LOCAL NEEDS ASSESSMENT REPORT

**Proposed Change of Use from C3 Dwellinghouse to C2 Children's Residential
Care Home (Up to 4 Children)**

5 Barnhill Lane, Hayes, UB4 9HD

Prepared by	V-Design CAD Services Limited
Date	29 July 2026
Planning authority	London Borough of Hillingdon

Drawing Title:	
Existing and Proposed Loft Plan	
Scale: 1:100, 1:50	Paper Size: A3

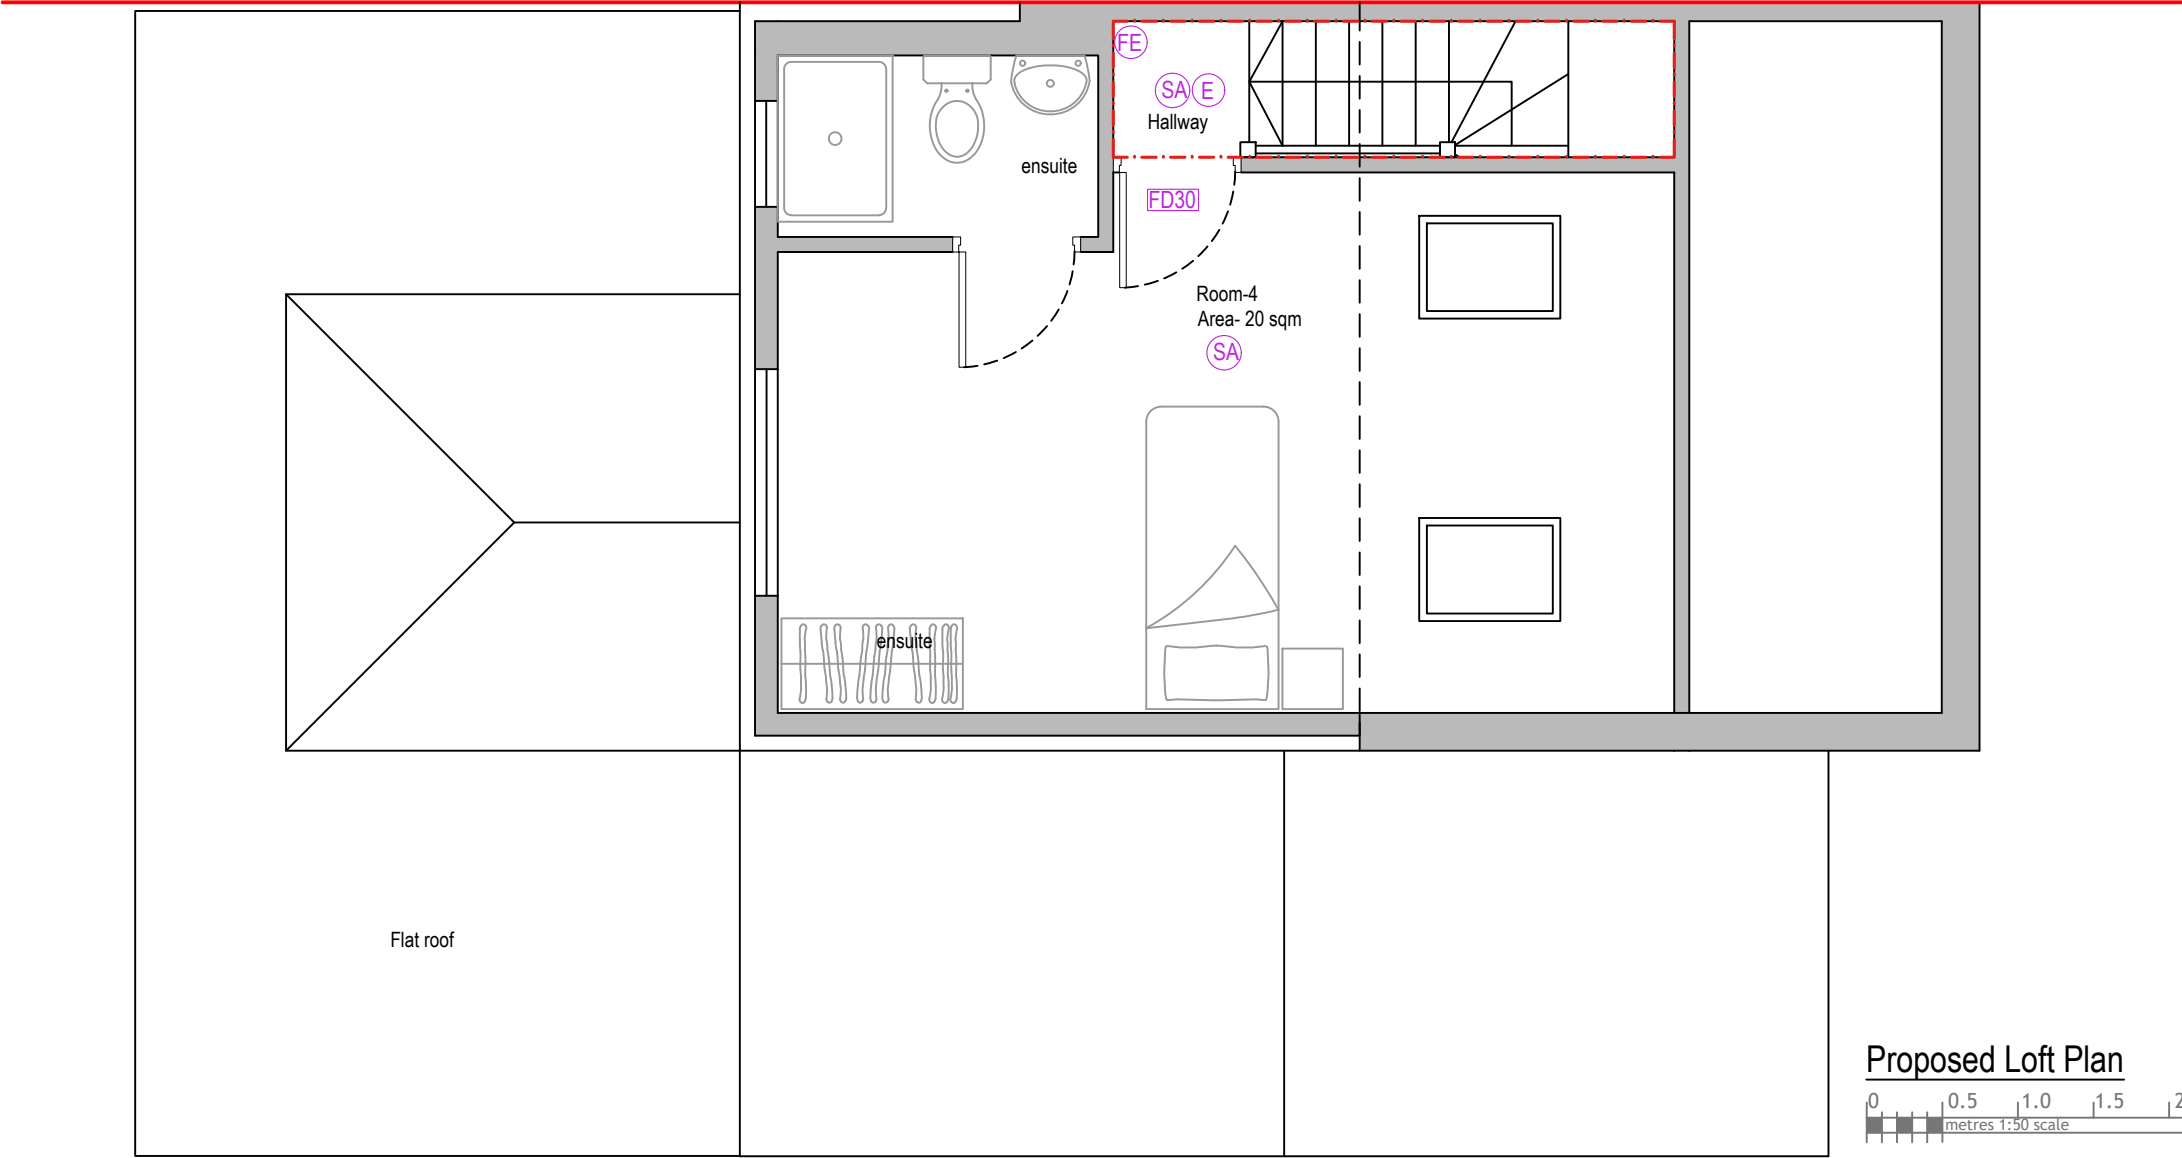
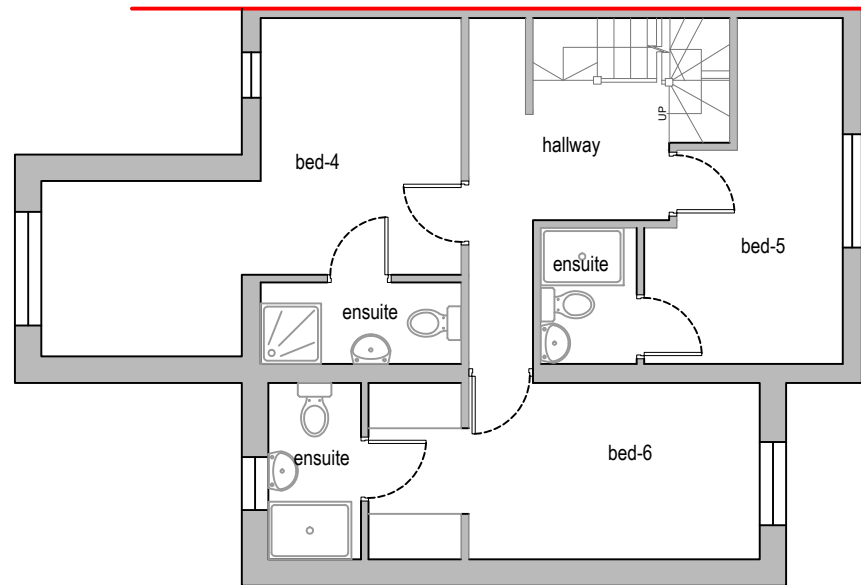
Element	Drawing evidence	Assessment / action
Resident accommodation	Rooms 1–3 on first floor: 15.46 m², 9.42 m² and 8.97 m²; Room 4 in loft: 20 m². Each is shown with an en-suite.	Four child bedrooms are identifiable. Confirm net usable areas and that sloping loft headroom is excluded where appropriate.
Communal space	Ground-floor kitchen/dining plus living room (10.86 m²).	Combined provision appears capable of supporting domestic routines, but furniture layouts and usable area should be

The 10.86 m² living room is supplemented by a substantially larger kitchen/dining area. The provider should confirm maximum occupancy of communal rooms, quiet/homework space and how children can spend time together or separately. The loft room requires confirmation of usable headroom, safe escape and thermal comfort.

Drawing Title:	
Existing and Proposed First Floor Plans	
Scale: 1:100, 1:50	Paper Size: A3

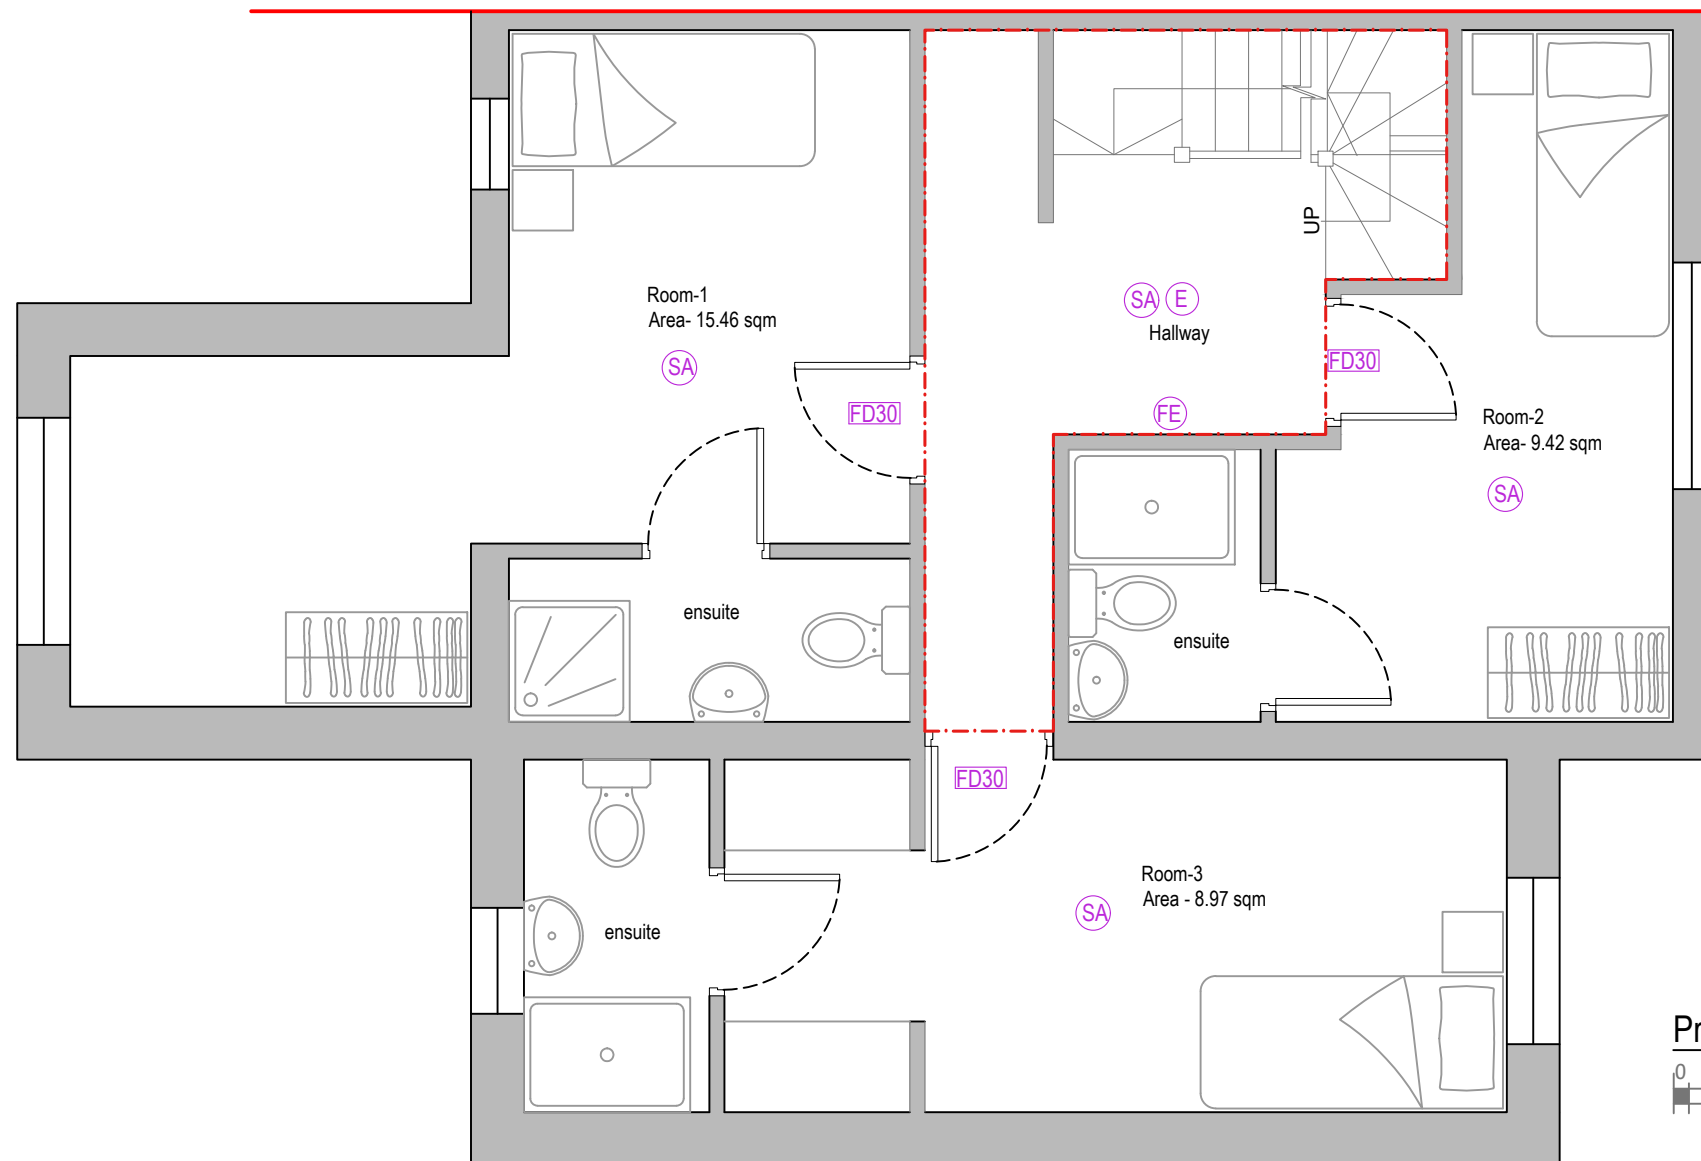
Four individually identified en-suite bedrooms and separate communal/staff functions are shown. Room 3 is annotated 8.97 m² and Room 2 9.42 m²; these are relatively compact. There is no specific national planning space standard for C2 children's bedrooms, but the applicant should demonstrate that each room accommodates a full-size bed, storage, desk/study provision, circulation and personalisation without crowding.

Drawing Title:
Existing and Proposed Ground Floor Plan
Scale: 1:100, 1:50 Paper Size: A3

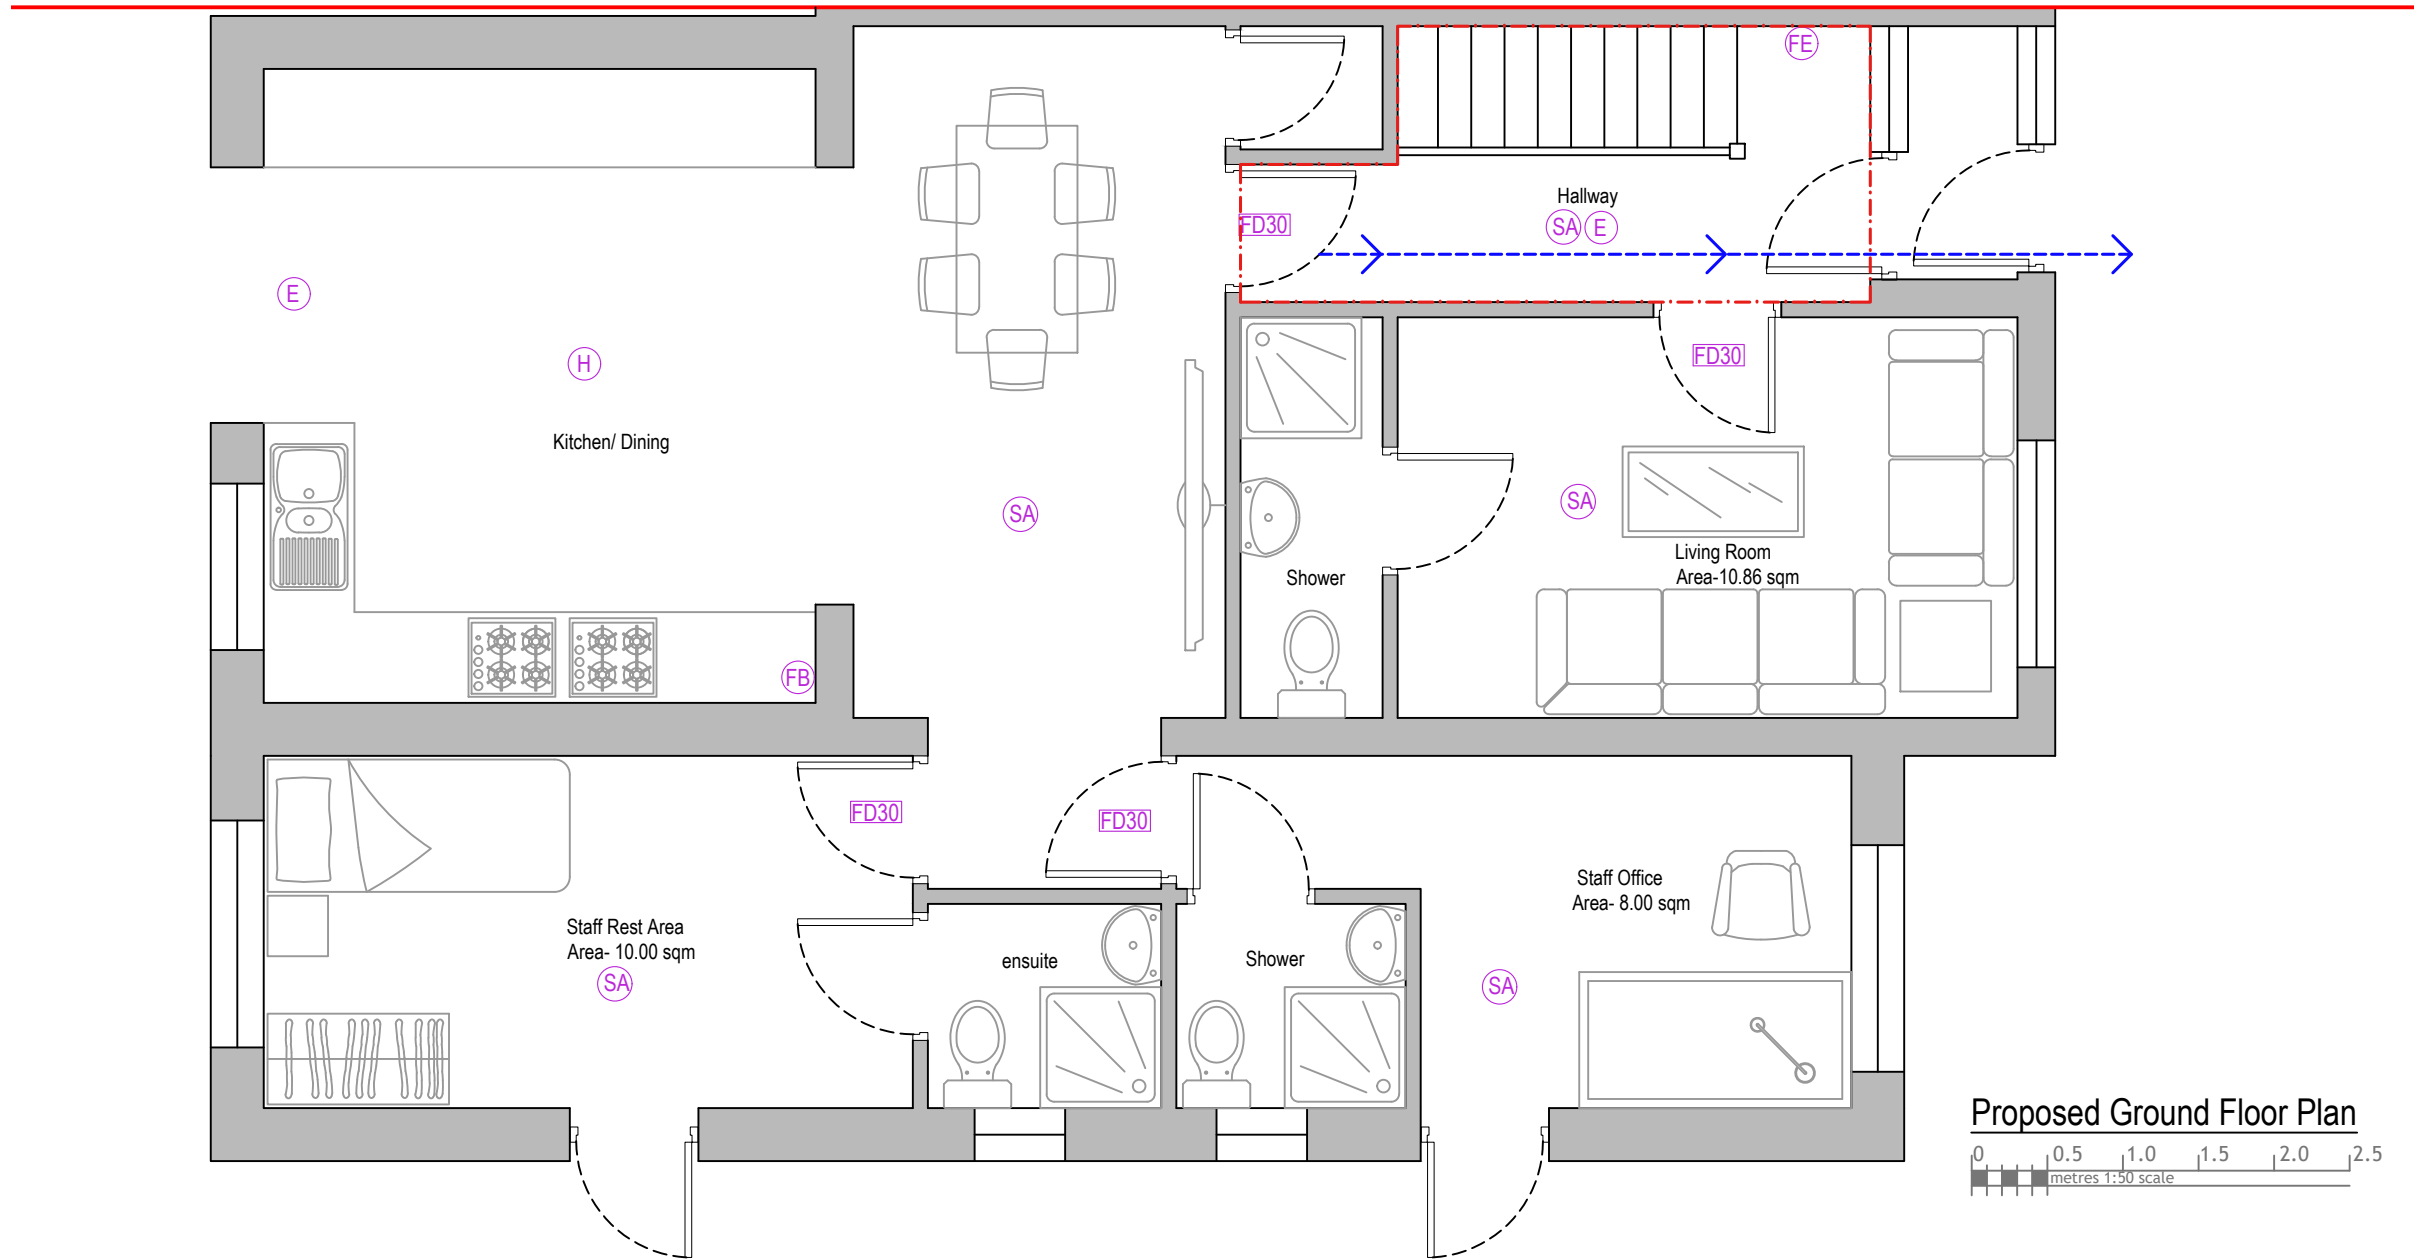
confirmed. Avoid treating bedrooms as substitutes for communal space.
Staff facilities	Ground-floor office (8.00 m ²), staff rest area (10.00 m ²), shower/WC.	Supports 24-hour management. Clarify whether the rest room is a sleep-in room, waking-night base or both, and the maximum staff present overnight.
External amenity	Private rear garden retained.	Positive for recreation and wellbeing. Provide boundary, supervision and maintenance controls in the OMP.
Parking / cycles	Two car spaces, four cycle spaces, EV charging and bin storage.	A reasonable physical provision for a small home, subject to a staffing/visitor schedule and safe manoeuvring.
External appearance	No changes to elevations.	Limits design and streetscape effects; any signage, lighting, CCTV or security apparatus should remain domestic and discreet.
Fire / escape	FD30 doors, alarms, emergency lighting and protected escape route are annotated.	Positive indication only. Building Regulations, fire-risk assessment and Ofsted registration remain separate statutory processes.
